Comments on the Applicant's Responses to Deadline 4 Submissions [part 11 – Response to Mr Moore and Dr Moore]

Unique Reference Number: 20040614

In their Section 2, which actually does relate to me, Tritax have responded to my document "Response to the Examining Authority's Written Questions and Request for Information ExQ1 Question 1.8.18 regarding the Applicant's methodology for noise assessment in the proposed Hinckley National Rail freight Interchange." of the 9th January 2024 (Deadline 4).

00:00 on 24/04/2021 to 00:00 on 25/04/2021

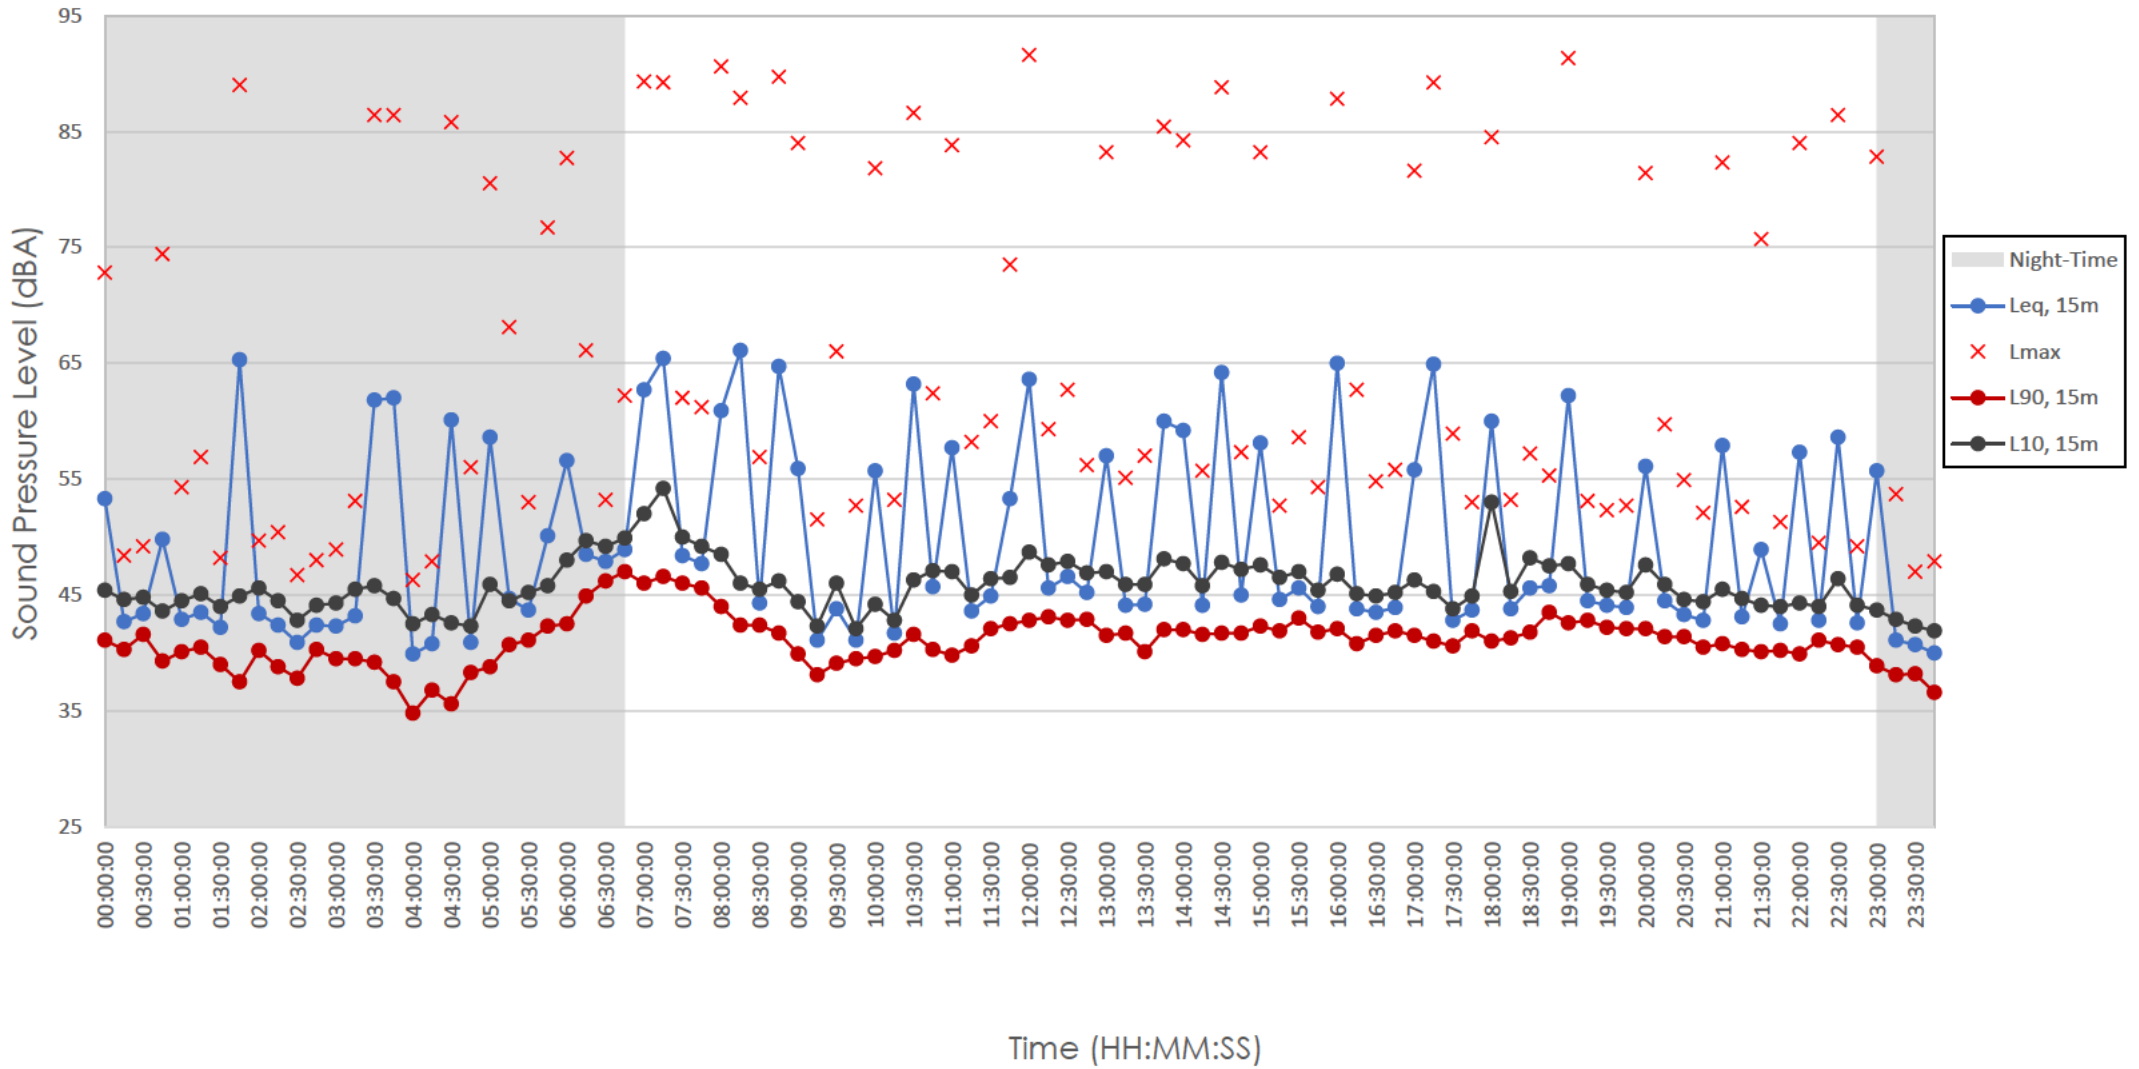
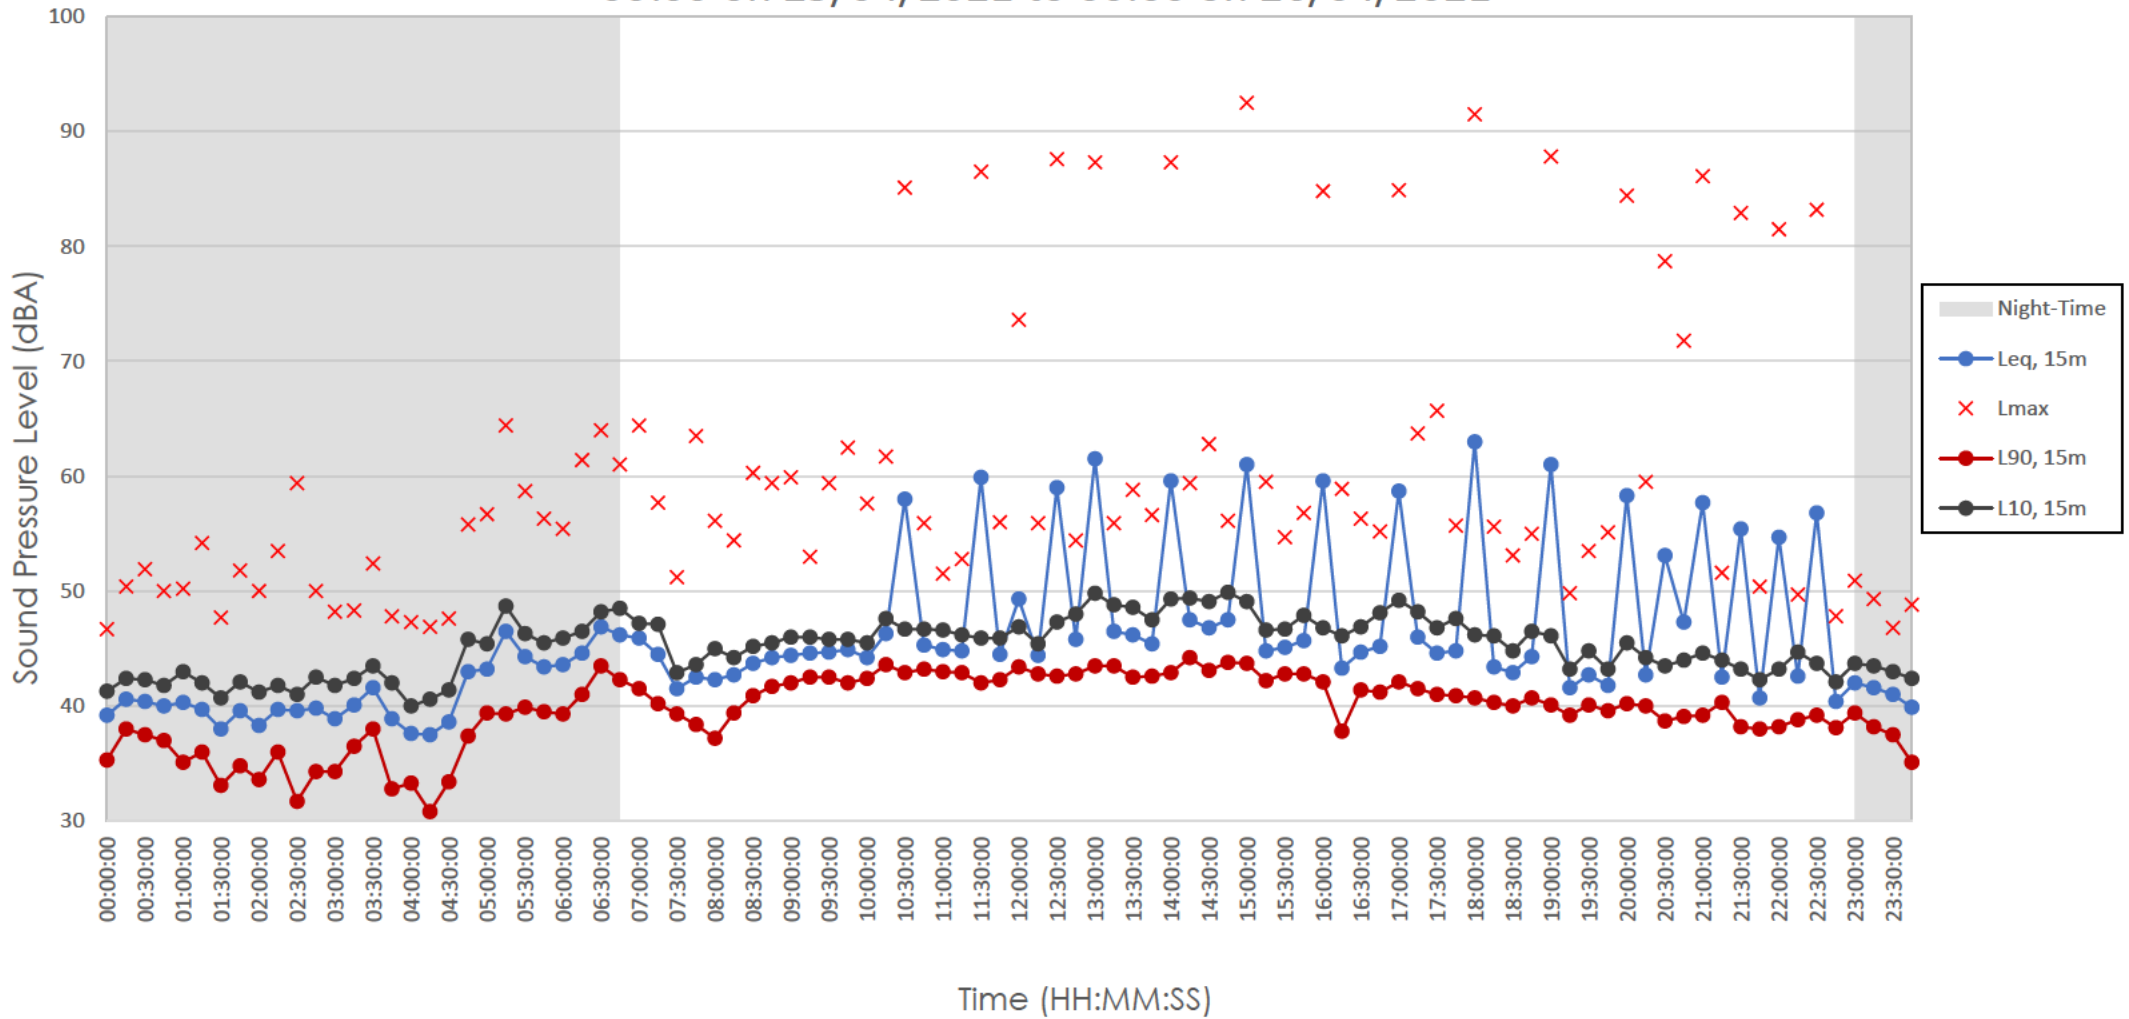
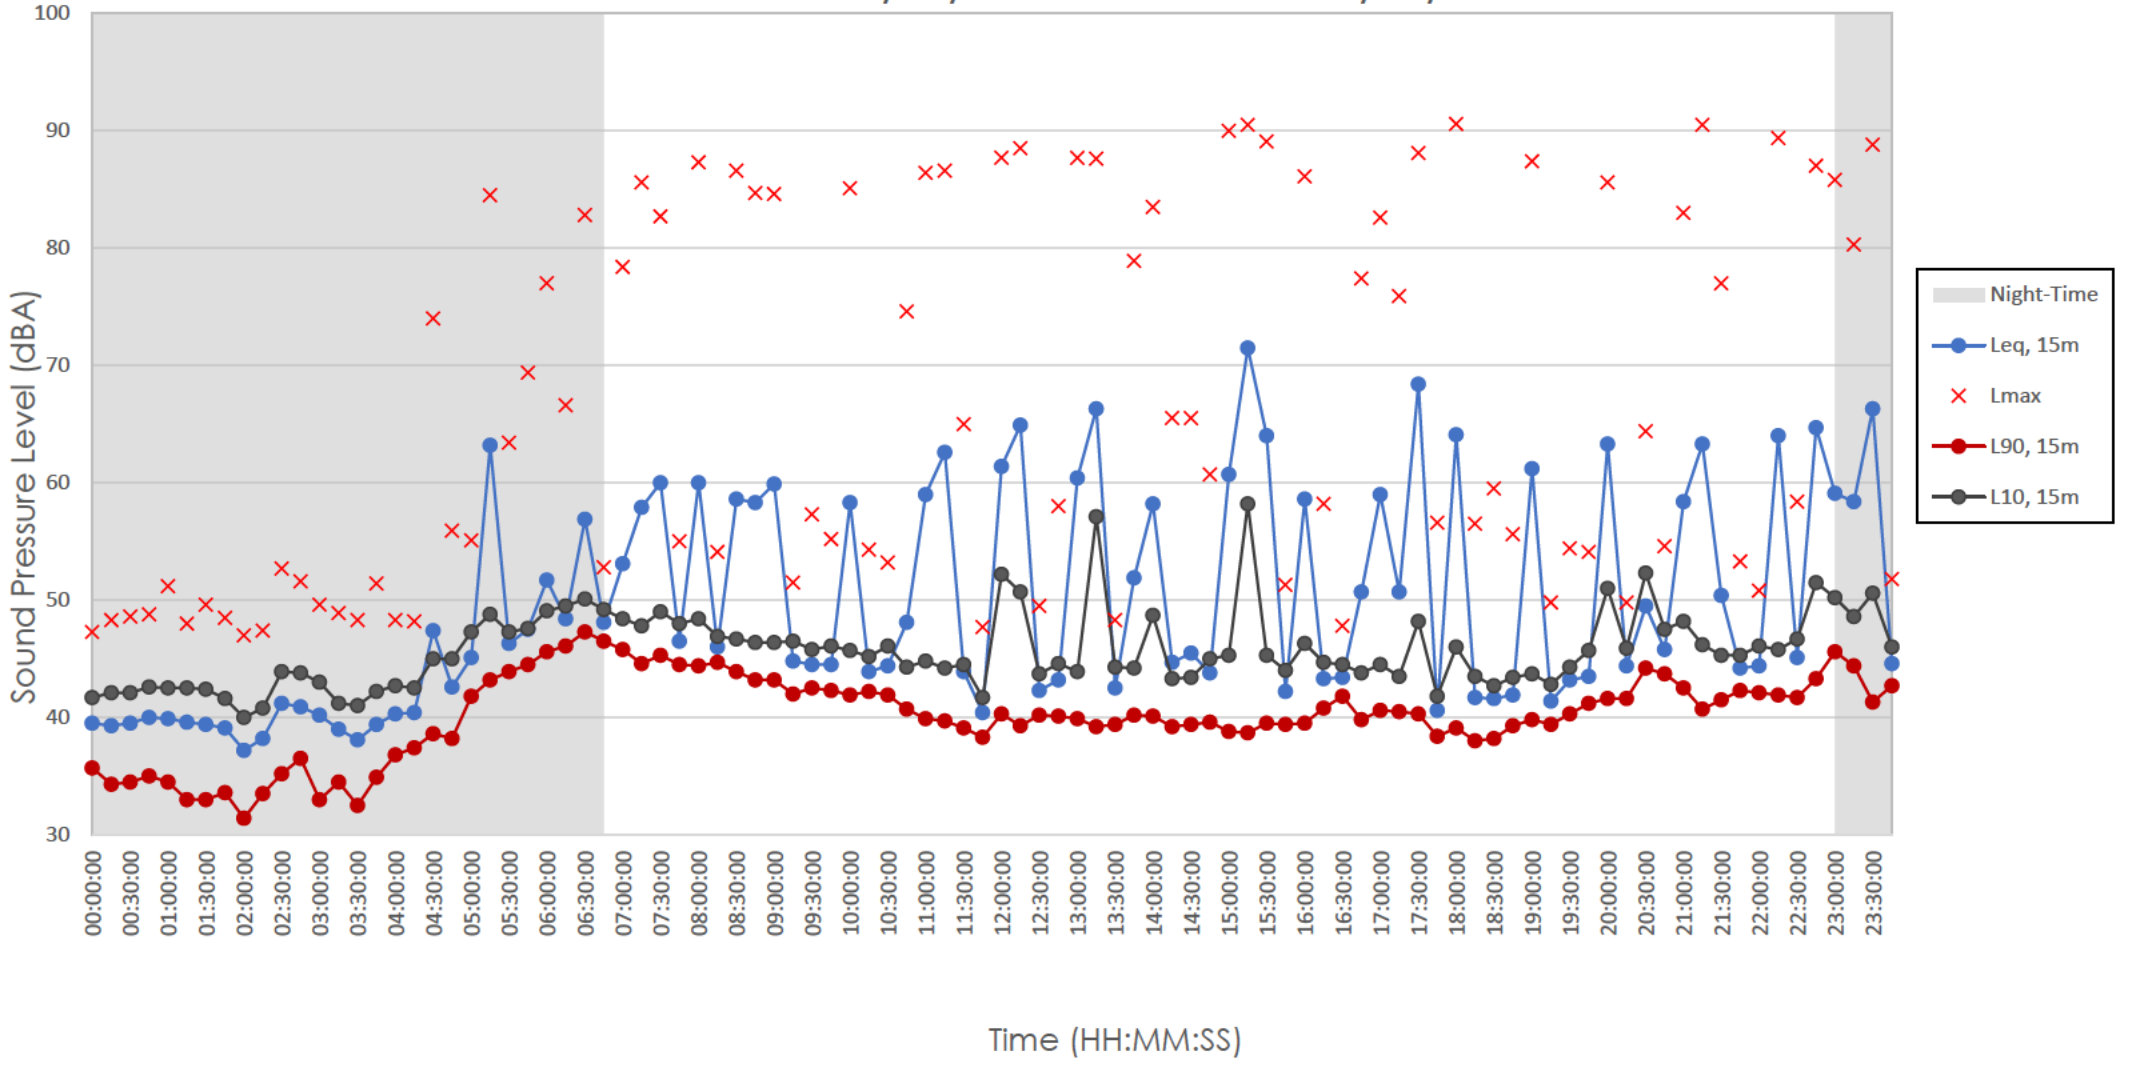
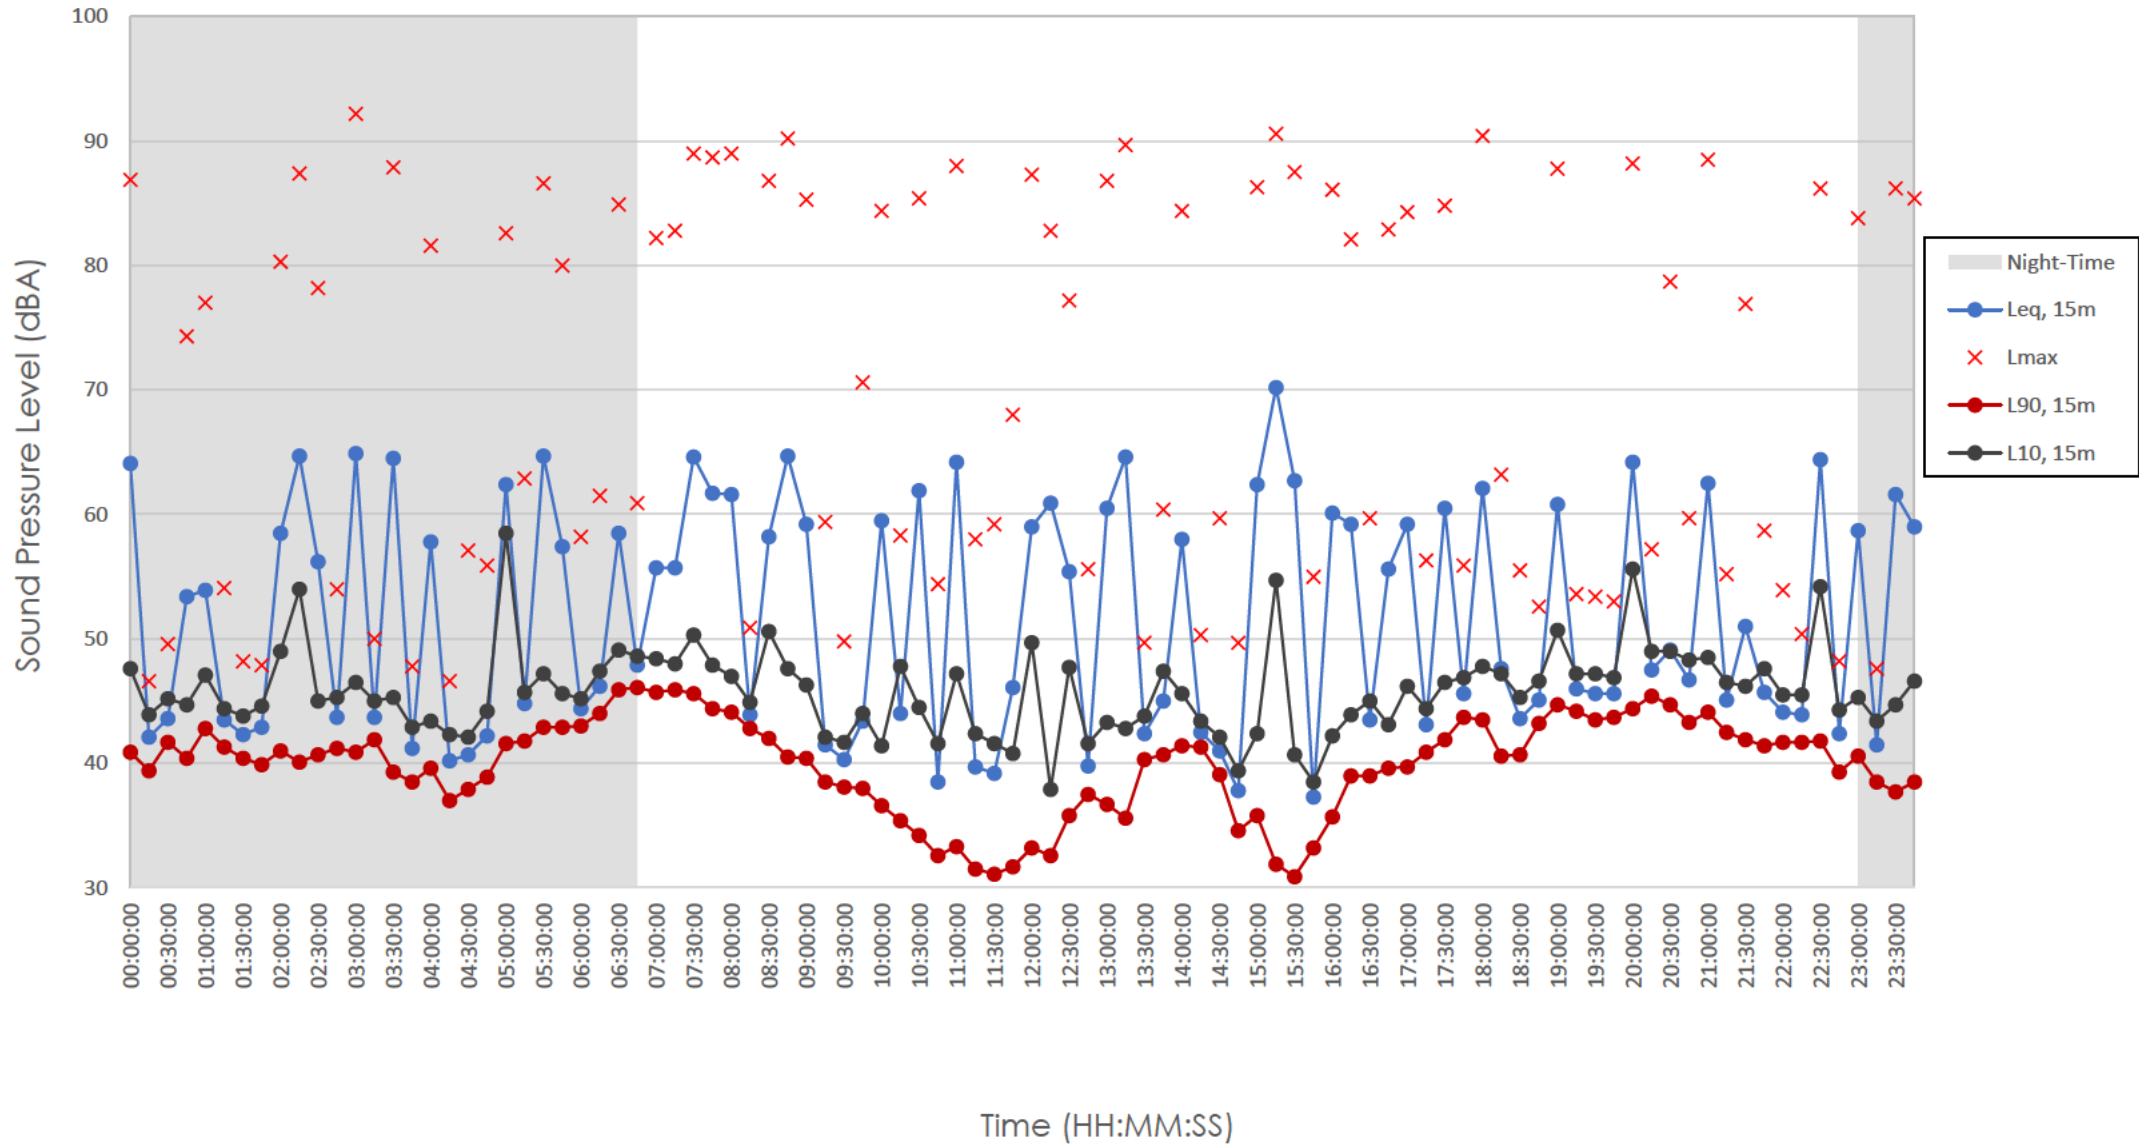
Moreover, the noise levels Tritax measured at the trackside and indicated in graphical form in Tritax’s ES Appendix 10.10 “Summary Results” are entirely in line with the train passby characteristics that I have indicated.

Tritax’s statement is incorrect, as I shall explain. The noise levels measured at the trackside over the 7-day period are continuous along the length of the line that is considered here, **and no rail noise maps are required**. Further, the DEFRA rail noise maps that Tritax have sought to introduce are intended for use only at a strategic level and are very much higher (12dB to 15dB) than the noise levels that Tritax measured at the trackside at NMP3 and NMP4 over the 7-day period and then used as a foundation of their Noise and vibration report.

Moreover, the DEFRA rail noise maps give no indication of the noise levels at Weekend daytimes or Weekend night-times, and indeed are so broad-brush that they indicate a **higher** rail noise level at night-time than daytime. In contrast, the noise levels Tritax measured at the trackside over the 7-day period give detailed information for both Weekends and Weekdays, and both daytime and night-time.
